From: [REDACTED]
To: [SizewellC](#)
Subject: Response to Issue Specific meeting ISH 11
Date: 14 September 2021 12:25:00
Attachments: [Responses to ExQ2 REP7-052 and REP7-059 Nick Scarr.pdf](#)

Responses to REP7-052 (EN010012-007054- Responses to ExQ2) and REP7-059 (Comments at Deadline 7 on Submissions from earlier deadlines and subsequent written submissions).

This paper is a response to the Applicant's replies to enquiries made by the Planning Inspectorate relating to my documents.

Figure 13: The Beast from the East storm, 2099 Sea Level – Post-storm bed elevation for the SCDF with present-day shoreline (left) and SCDF-future shoreline position (right) cases. (BEEMS Technical Report TR545)

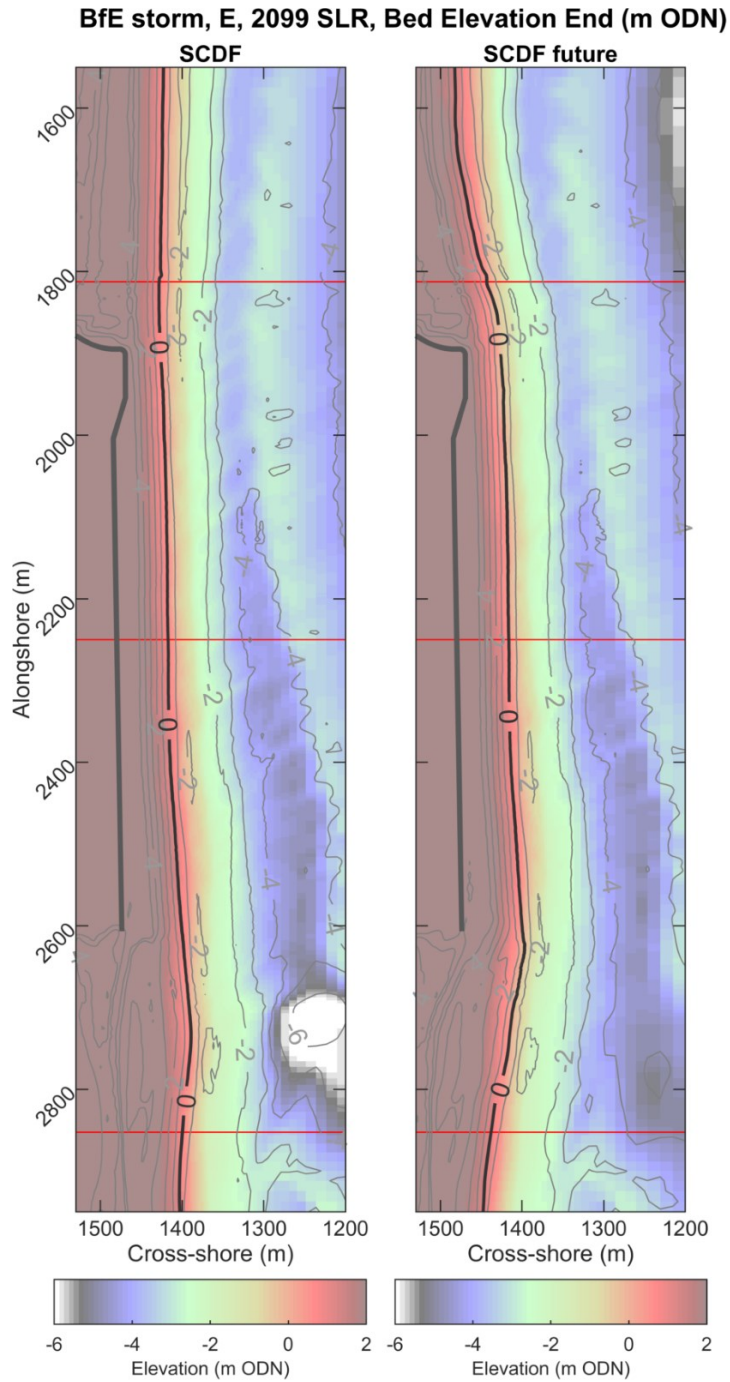
The Applicant’s claim that TR545 modelling satisfies the ‘*uncertainty around the bank and its role in shoreline change*’ by ‘*by virtue of the model boundary being inshore of the bank but with wave conditions offshore of the bank applied to the boundary*’ is not valid in my opinion, for the following reasons:

TR545 is confined by its defining parameters which also make it unsuitable for wider consideration:

- 1) The choice of storms modelled (moderate to low wave heights and water levels).
- 2) The use of mid-range climate change sea level rise.
- 3) No regard for storm surge in the BofE modelling (and only a very limited consideration in other modelling).

4) Limited scope in not considering the impacts of northern coastline breaches.

5) An unsupportable reliance, in my view, on treating offshore wave attenuating geomorphology such as at least the inner and outer longshore bars as ‘immutable’— i.e., permanently resilient. The alongshore bars will have a marked effect in preventing erosion from more modest storms such as the BofE and, could change or be lost in event of an absent Dunwich bank.

The limited and ‘particular’ nature of TR545 modelling, in and of itself, could be acceptable. However, the meaning of TR545 needs careful consideration; TR545’s claims to conservative (precautionary) modelling are, in my opinion, mainly misplaced as shown in my document REP7-220 *and particularly so if such claims are contextualised to be representative of overall flood and erosion risk modelling of the proposed Sizewell C*. This is more fully covered in my document [REP7-220](#).
